Mr. Ernest Armijo
Transportation Development Dept. City of Albuquerque

Re: Project Number 2025-020126
4710 Idelwilde Ln. SE, Albuquerque NM, 87108

This letter is in regard to DFT meeting comments received from Transportation Development on Oct. 22, 2025.

S1

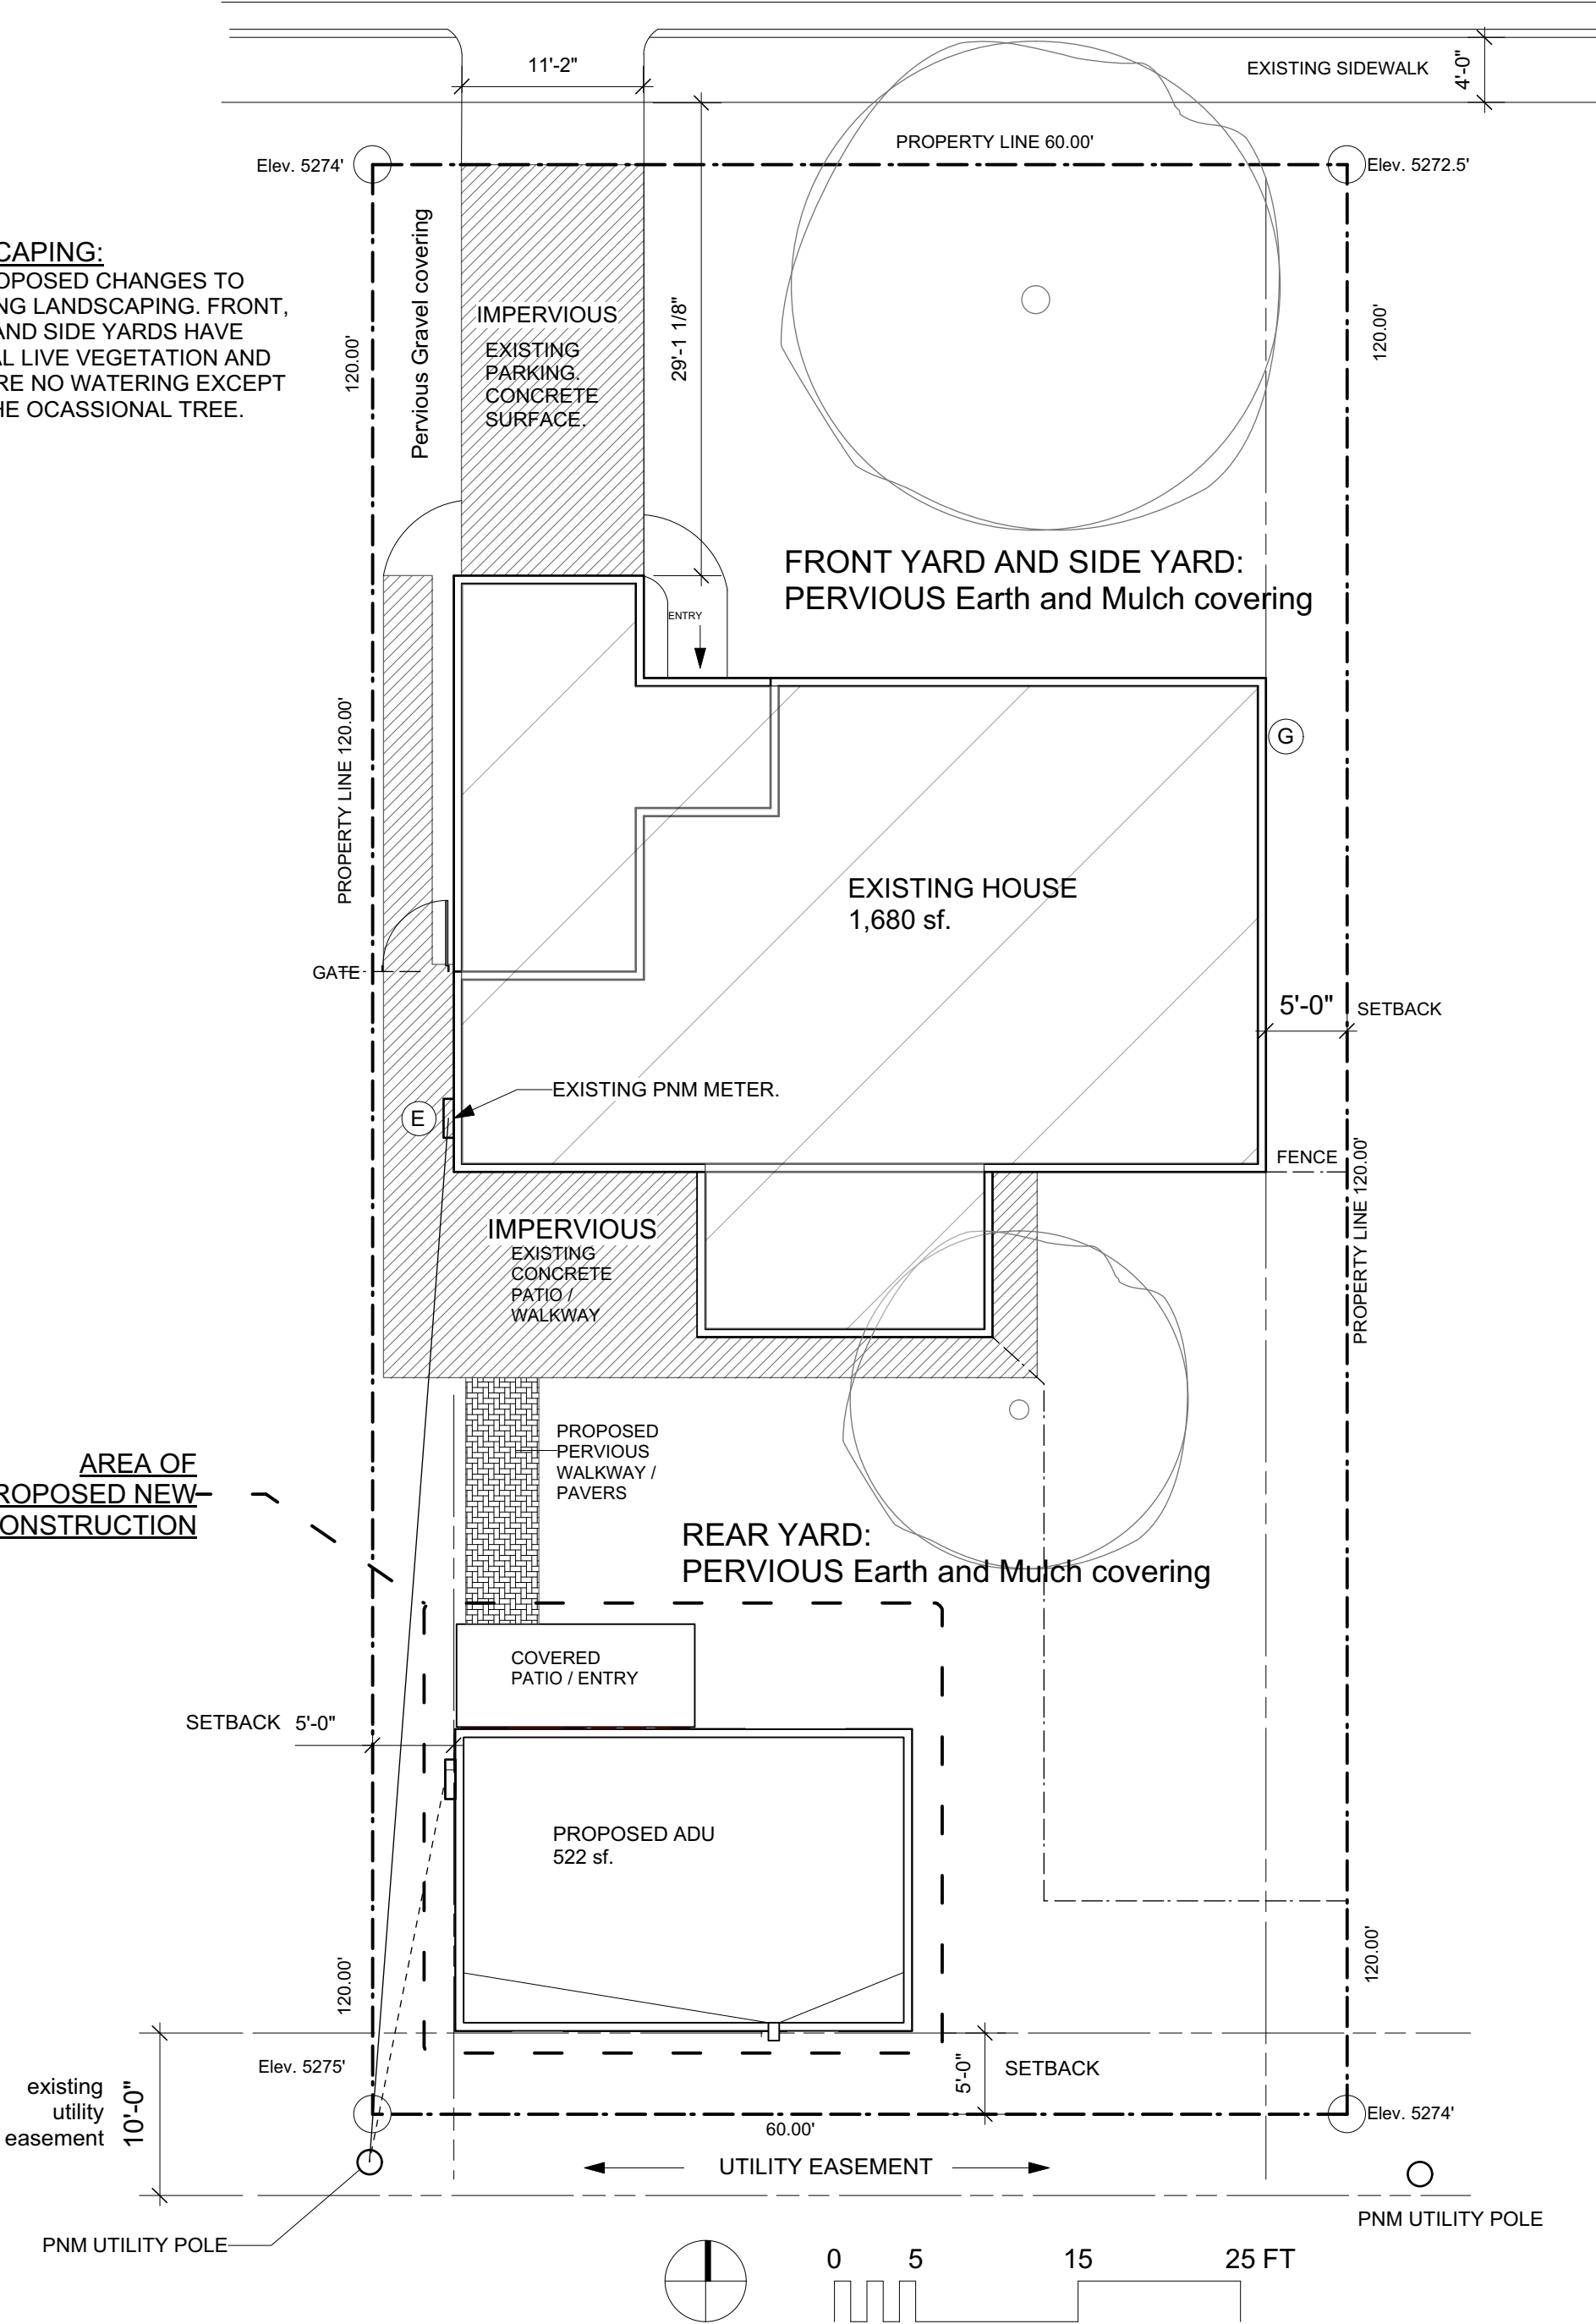
The Engineering comment stipulates that the street requires a 5' sidewalk be installed. The Parkland Hills Neighborhood is an 80 year old, fully developed residential neighborhood. The existing sidewalks are 4' wide and are consistent throughout the neighborhood. Idelwilde Ln. Is a low speed residential roadway. The only new construction proposed for the site is a small ADU in the rear yard of the house.

We are requesting that the 5' sidewalk requirement be reconsidered in this instance.

I have reviewed your request for a determination on the 5' sidewalk requirement and I am satisfied that the justifications given are sufficient to approve this request. Transportation will not enforce 5' sidewalks for this project.
